Sent: 02 November 2010 21:14
 To: Planning
 Subject: Welwyn Hatfield Council Online Planning - Comment

Application Number: N6/2010/2055/MA

Comment: I wish to register an objection to both planning applications 2010/2055/MA and 2010/2060/LB for the redevelopment of the site on Broadwater Road.

02. BRIDGE LEVEL PLAN : PROPOSED

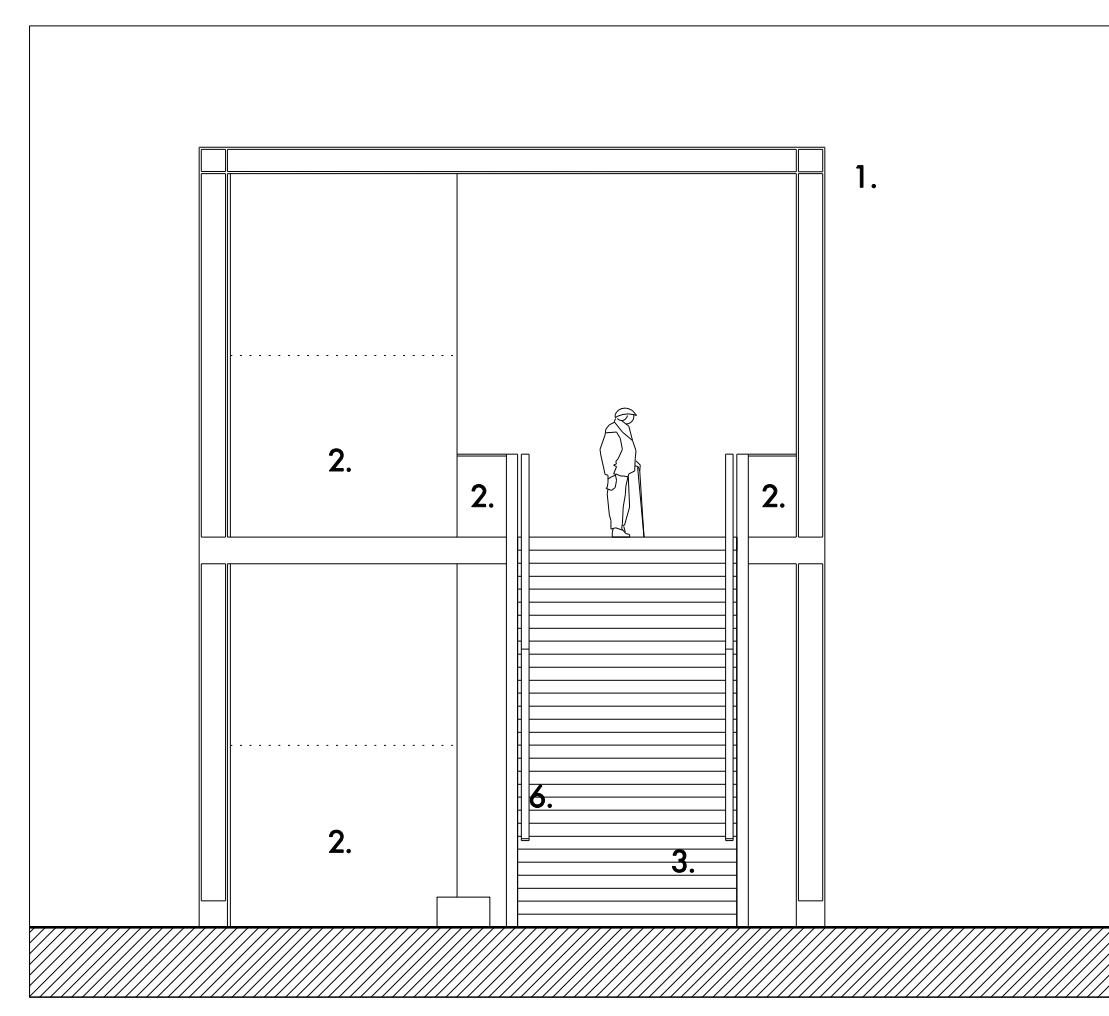
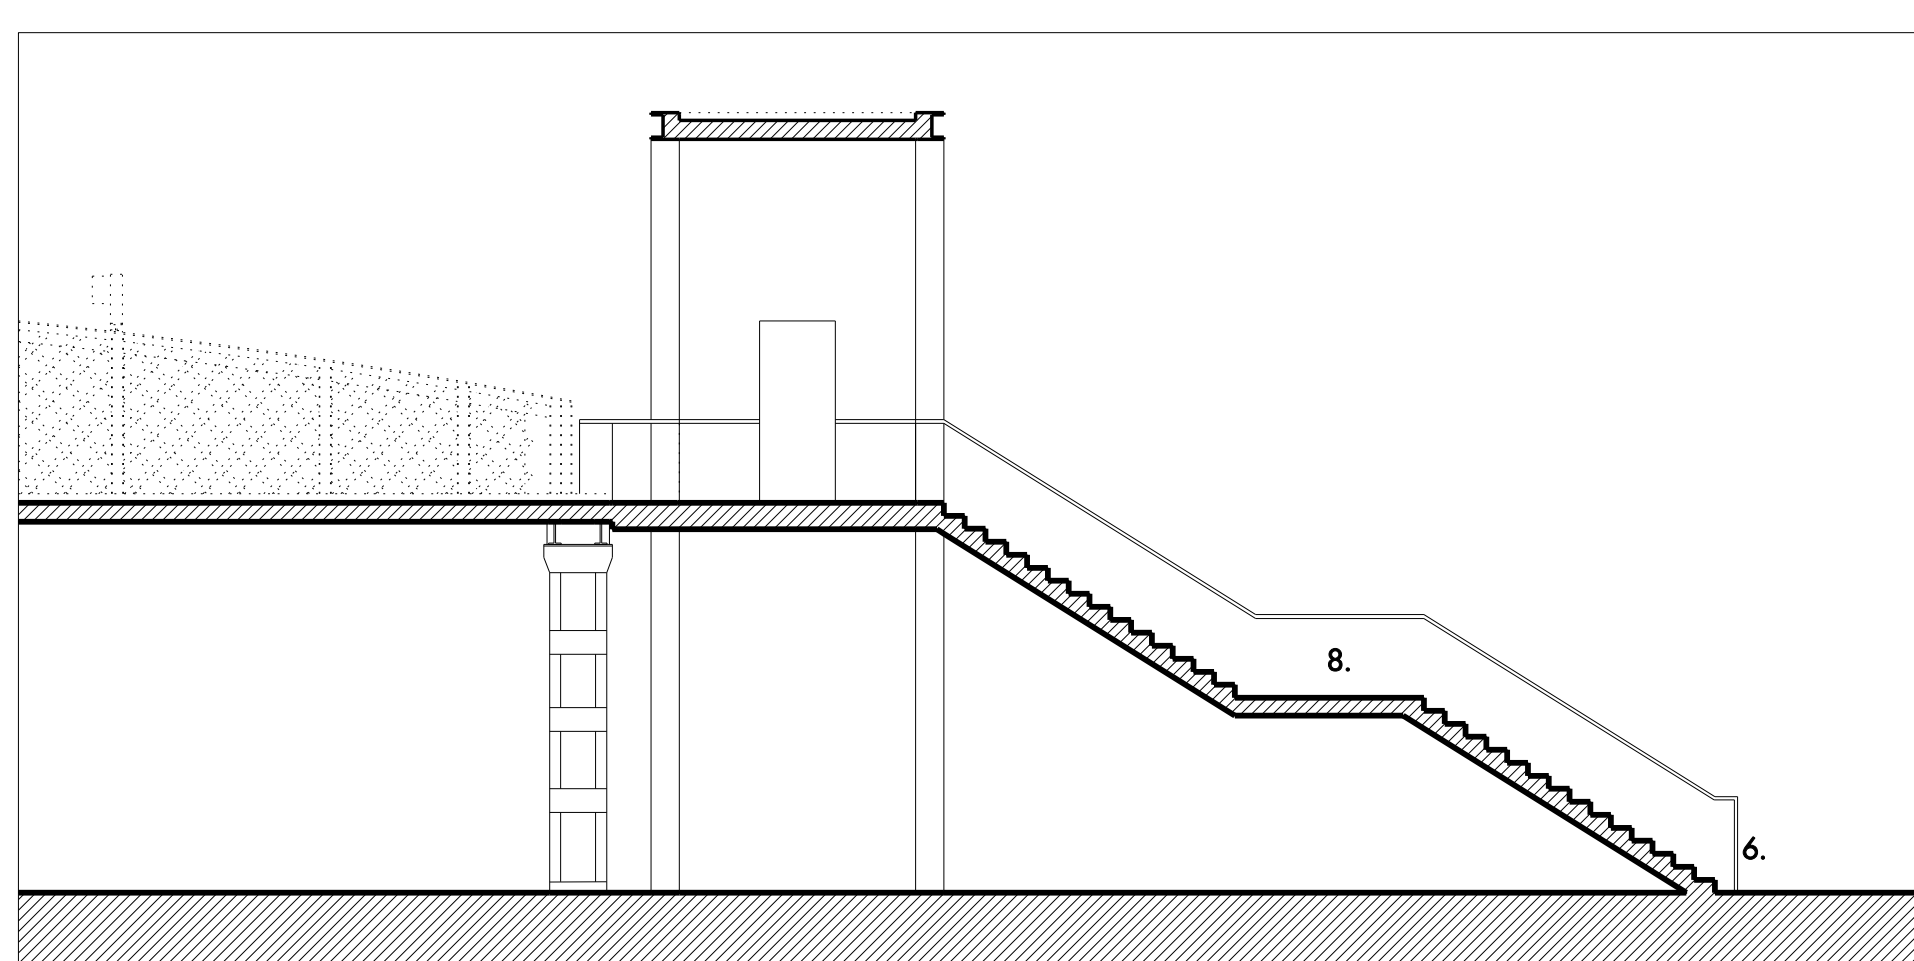
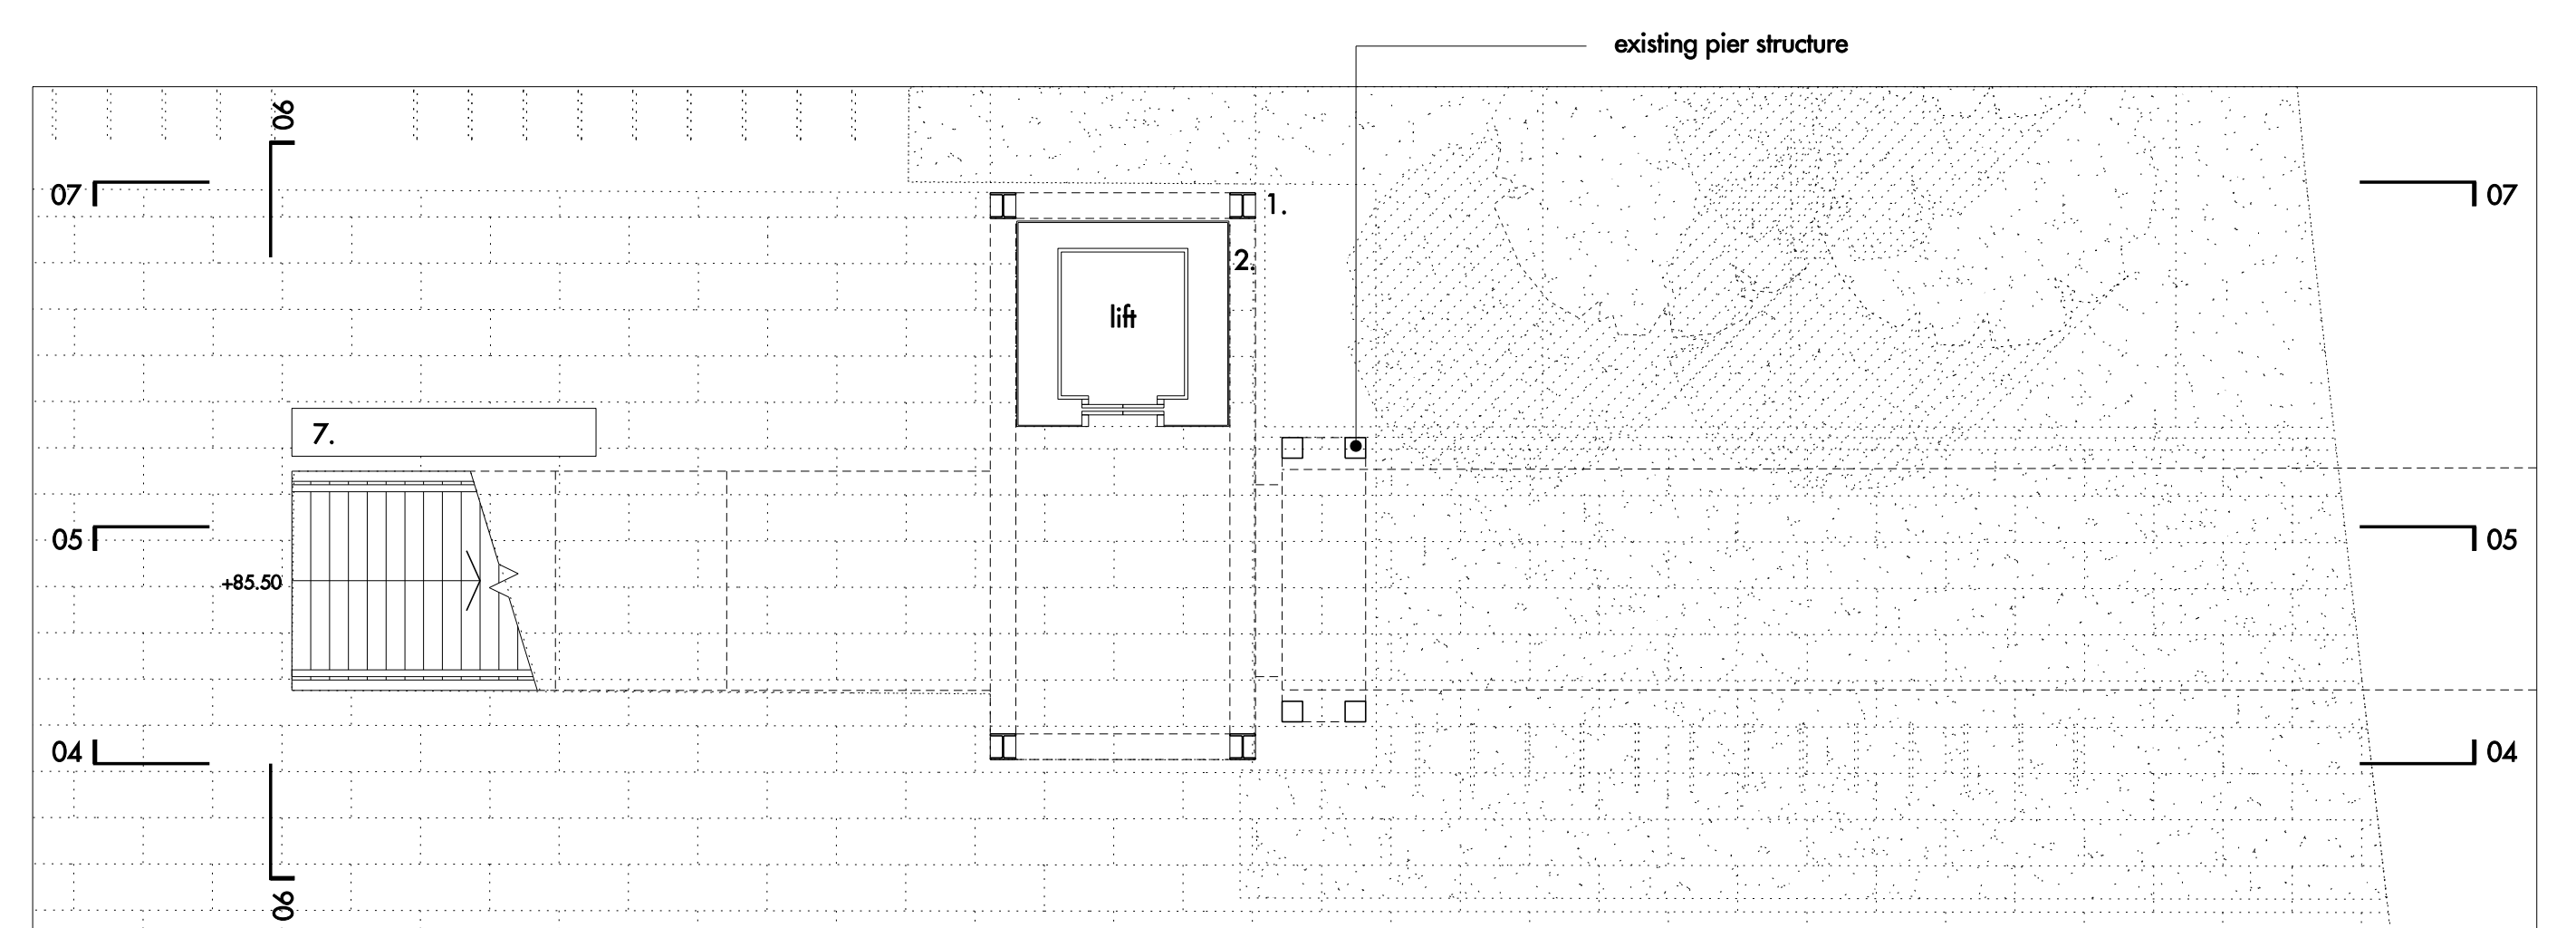
The application drawings indicate that the actual bridge is to be retained in its current condition with the narrowing bars remaining. Given the potential increase in pedestrian flows through this route this would not appear to be an acceptable solution or in line with the guidance in the SPG. The minimum clear pedestrian route that should be provided to enable 2 wheelchair users to comfortably pass each other is 1800mm wide (see BS8300:2009) and this should be required as a minimum. There are clearly already some structural issues with this bridge as its width was reduced 5+ years ago so it cannot be considered a suitable structure to provide adequate pedestrian access to the town centre.

The drawings also indicate a lift to be added to the structure however this does not contain a 1500 x 1500mm clear landing space at the upper level of the pedestrian route and should therefore be redesigned to ensure it meets current guidance.
